17 June 2019

**SECTION 4.55(1A) MODIFICATION APPLICATION TO MP08_0238 (MOD 13)
1 DENISON STREET, NORTH SYDNEY**

The modification relates to minor design changes resulting from detailed design development including:

1 Denison Street
North Sydney, NSW 2060
Building Elevation
East

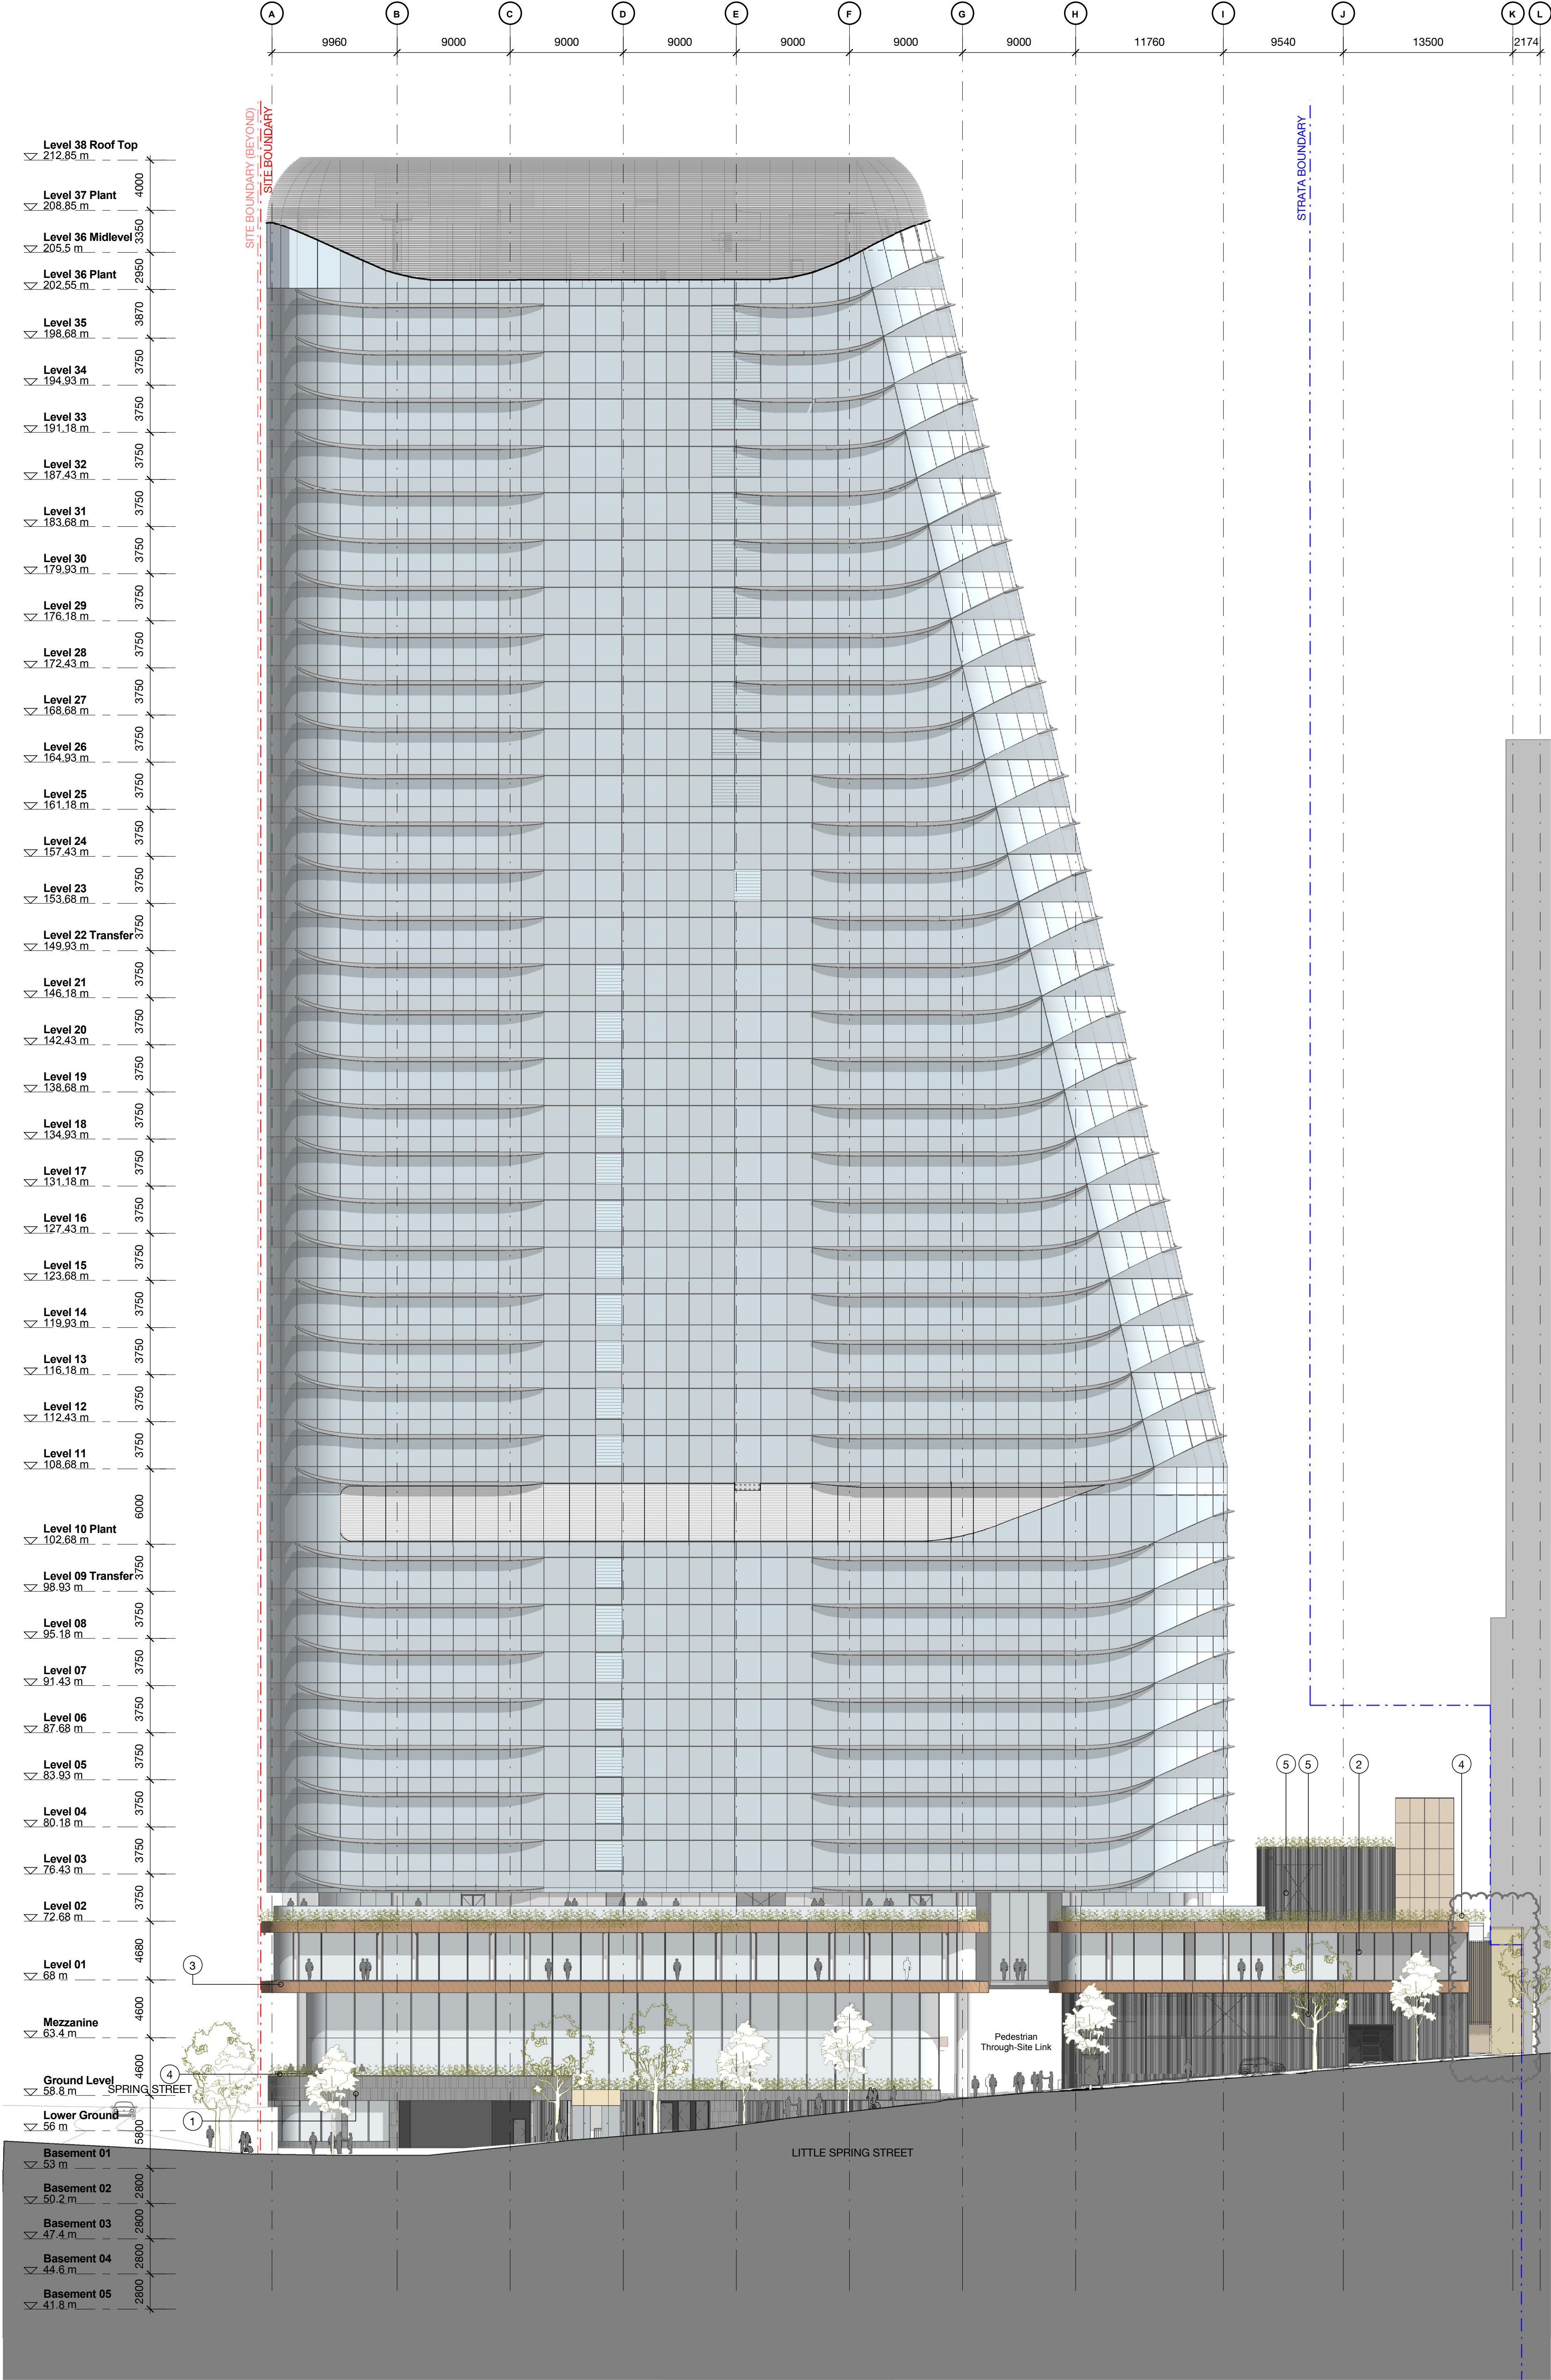
The proposal is limited to modifications to improve the amenity of Berry Square and a minor change to extend the approved façade precast panel on the eastern and western facades on the ground floor and level 01. The proposed continuation of the façade will be integrated into the approved design by matching with the approved façade. The proposed external modifications to the façade are within the approved building envelope and will not result in any significant visual impacts. The modifications to the public domain comprise of addition seating, a water feature and reconfiguration of the planting and paving areas. The proposed public domain amendments will not give rise to any adverse amenity impacts and improve the visual appearance and usability for future patrons.

1 Denison Street North Sydney, NSW 2060 Building Elevation West

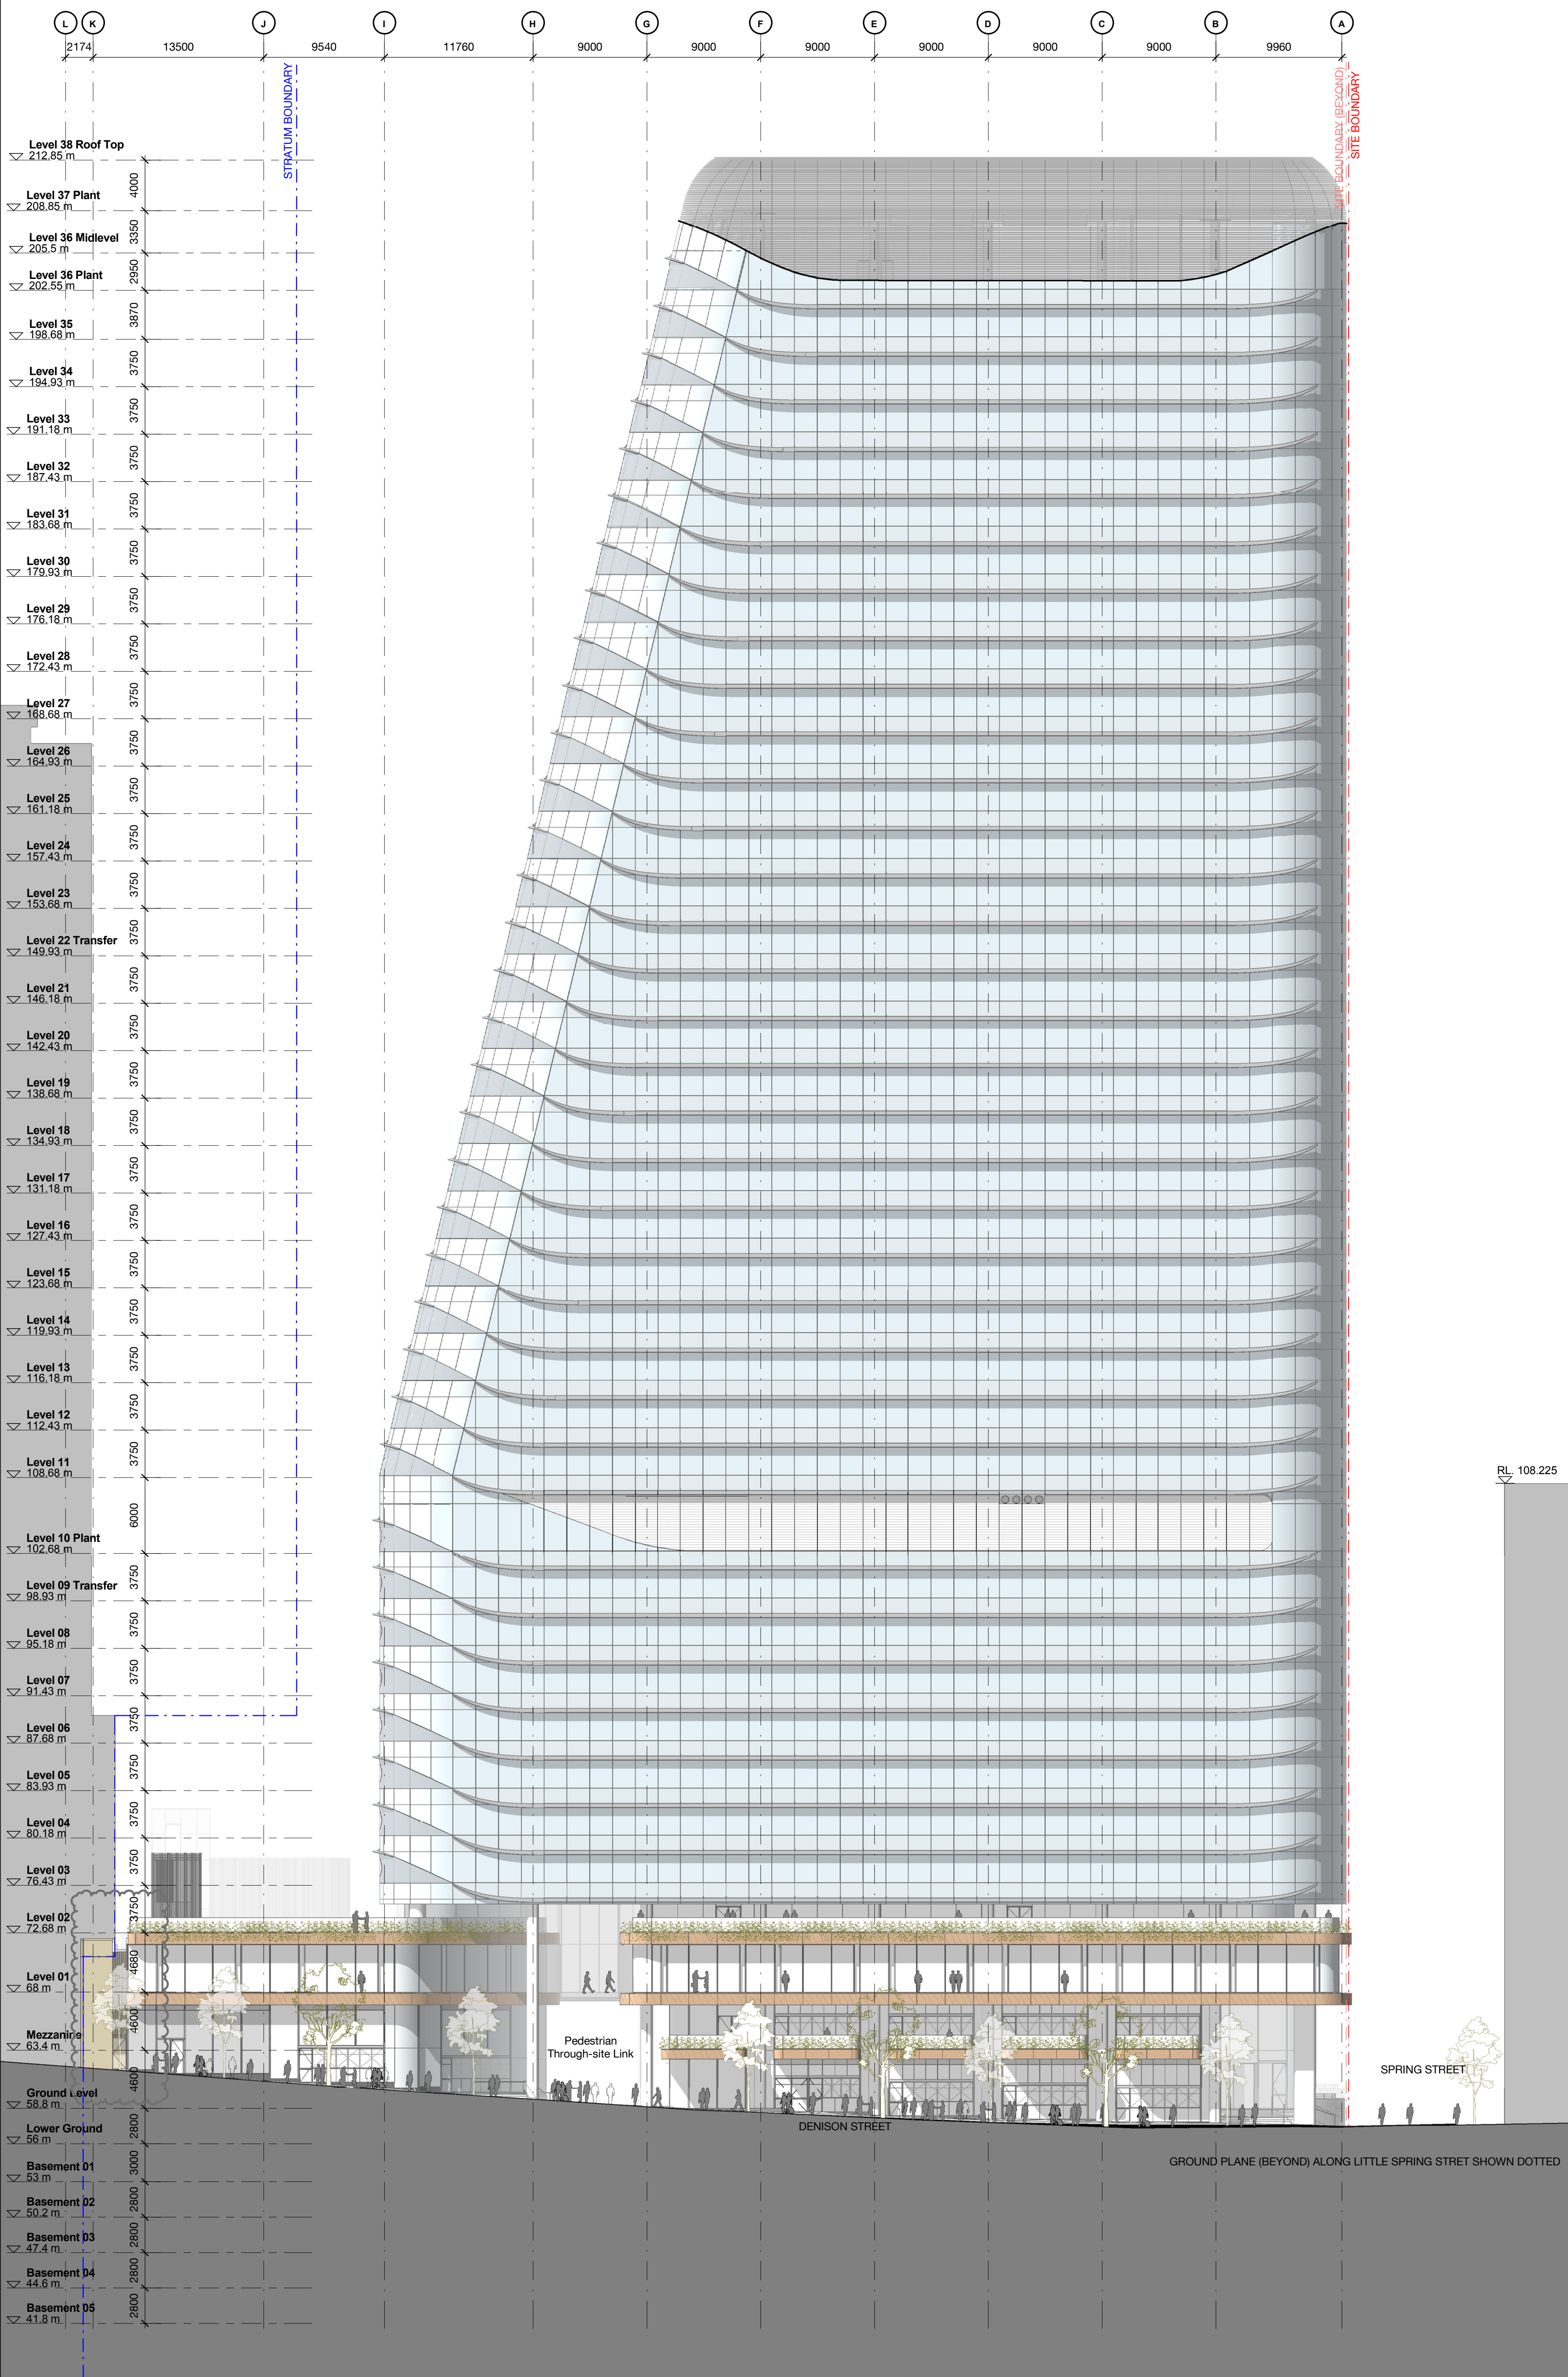
The proposed modification includes minor façade changes to extend the approved façade material to extend the precast panel on the western elevation for the Ground Level and Level 01. The façade changes are detailed on the proposed elevations provided in the Architectural Plans at **Attachment A**.
